Application no: H06-0389-11

Description: Detached double garage (retrospective)

Location: Chailey House
Chapelgate
Gedney
Spalding
PE12 0BJ
PE12 0BJ

Amendment: Amended position (dwg. no. 2104-10-03C)

SITE PLAN,
1/500.

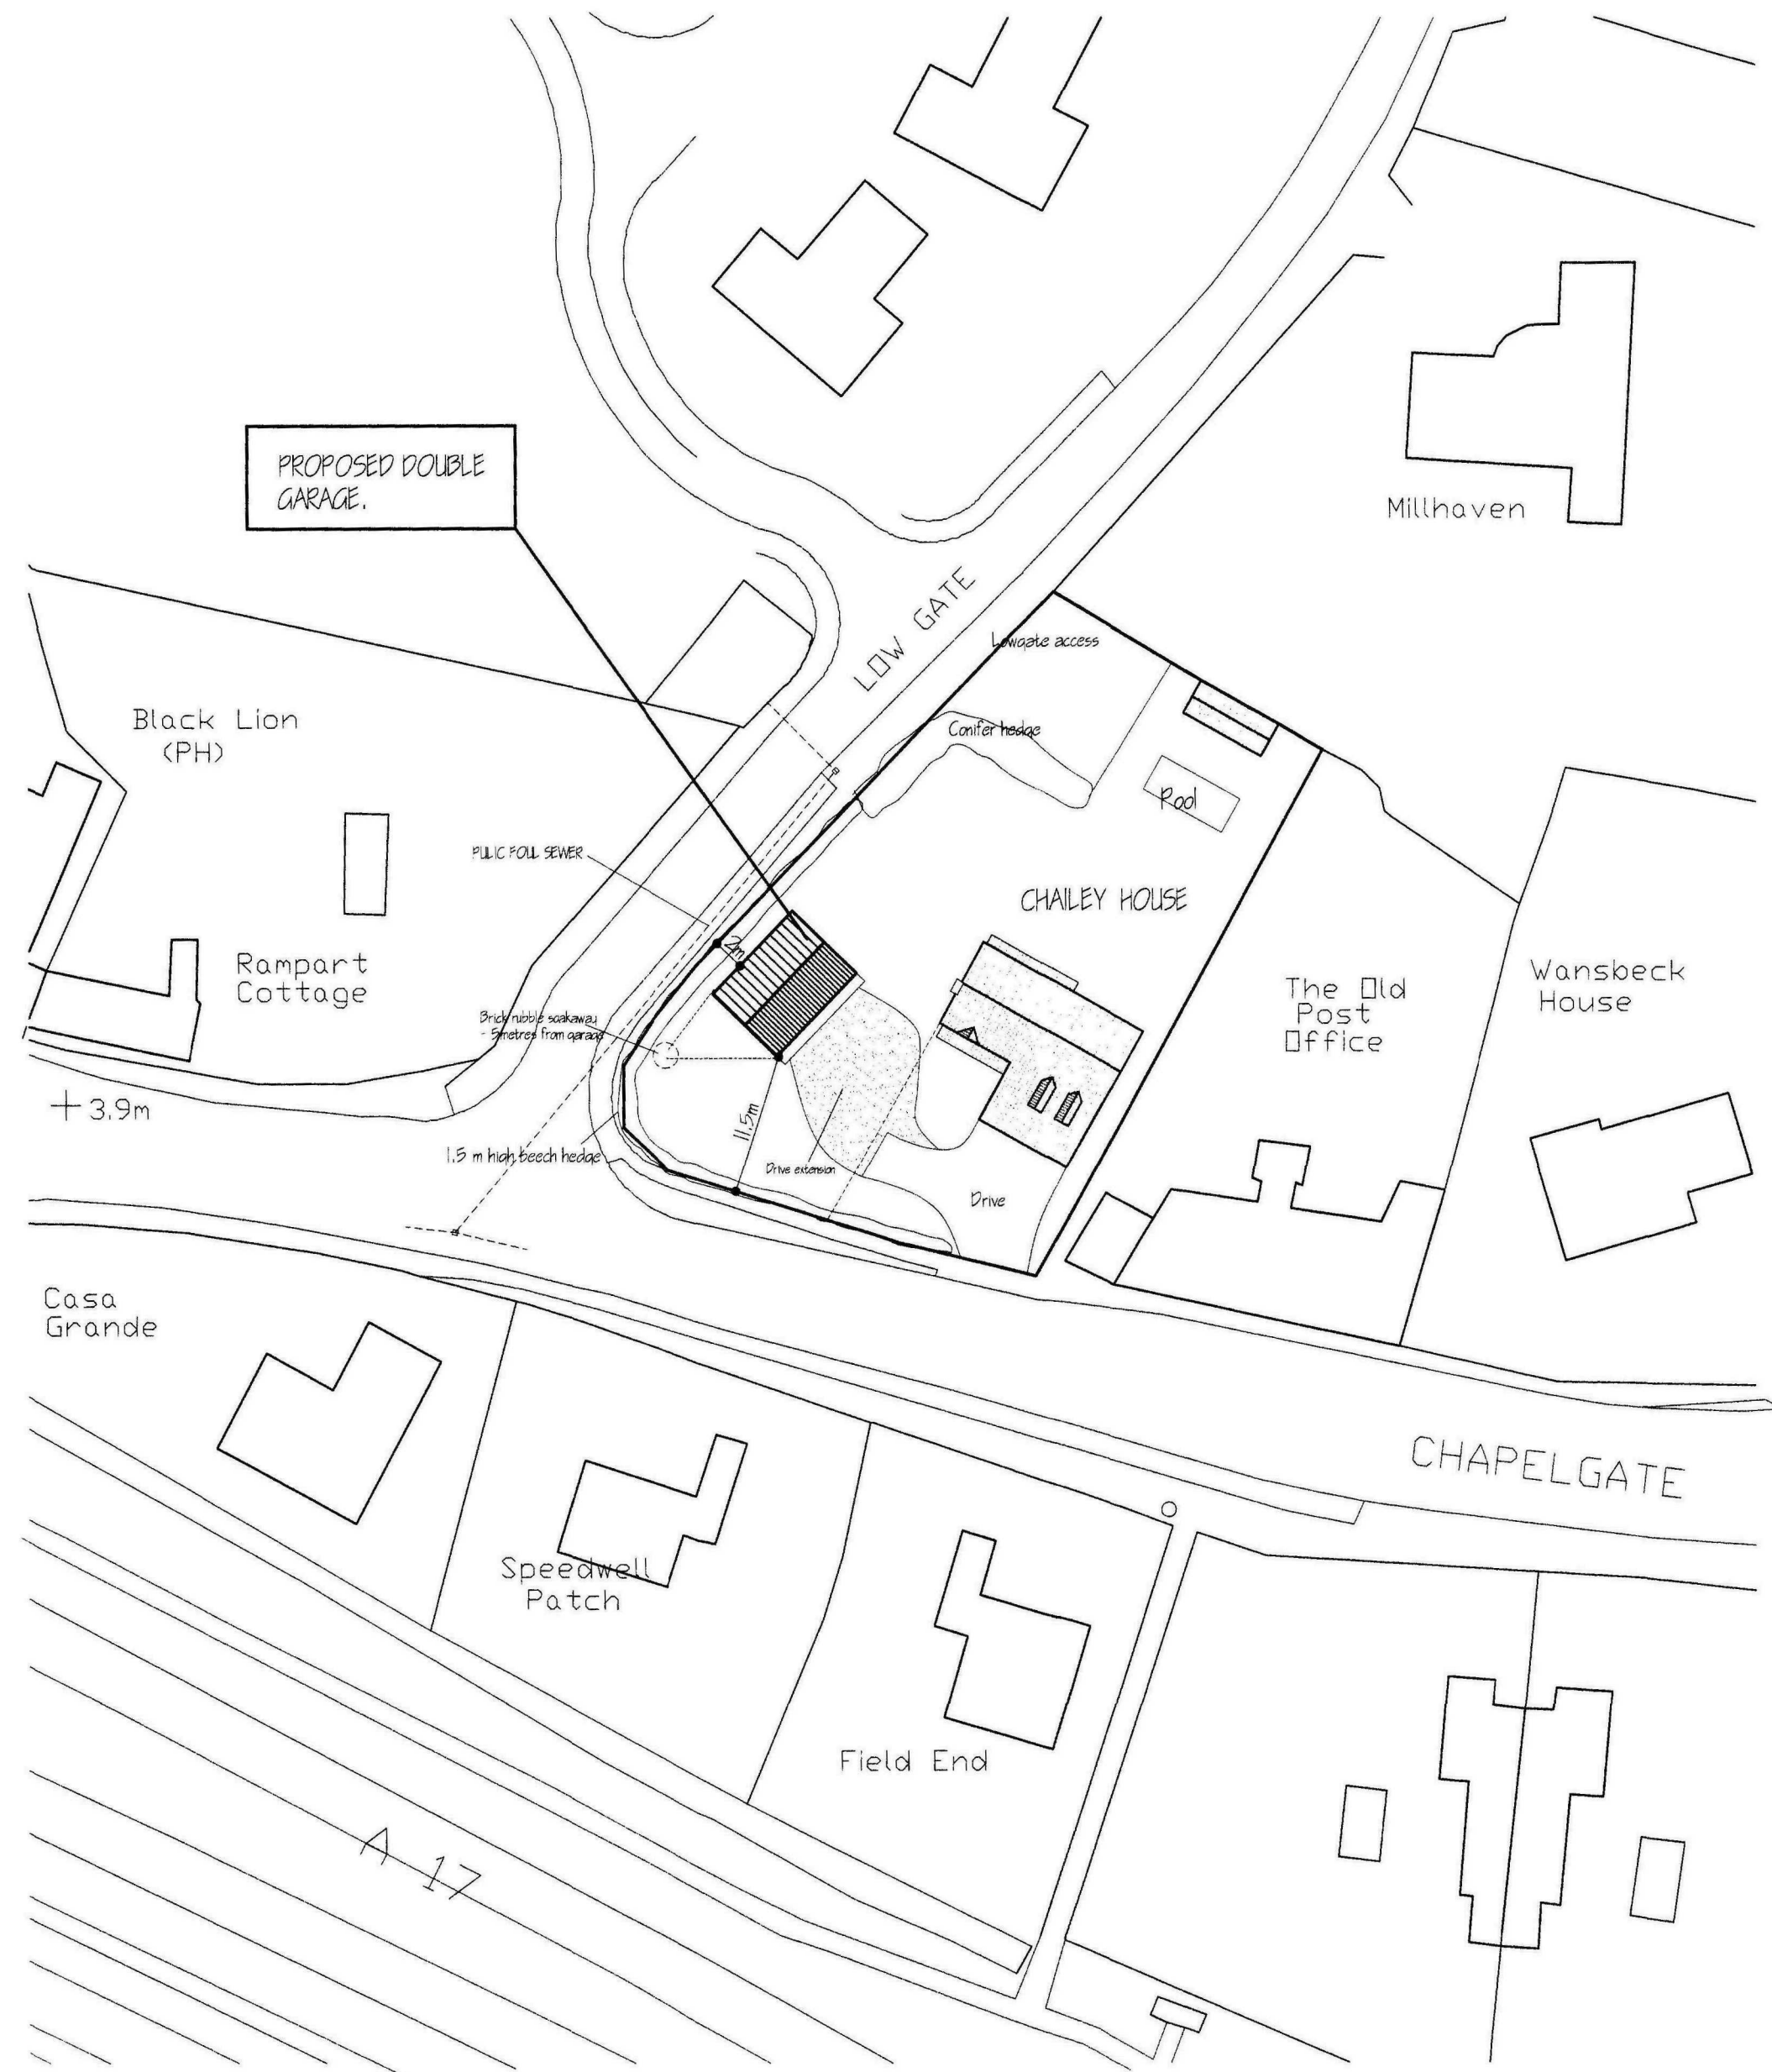
The garage is actually positioned 11.5 metres from Chapelgate see attached amended plan 2104-10-03C.
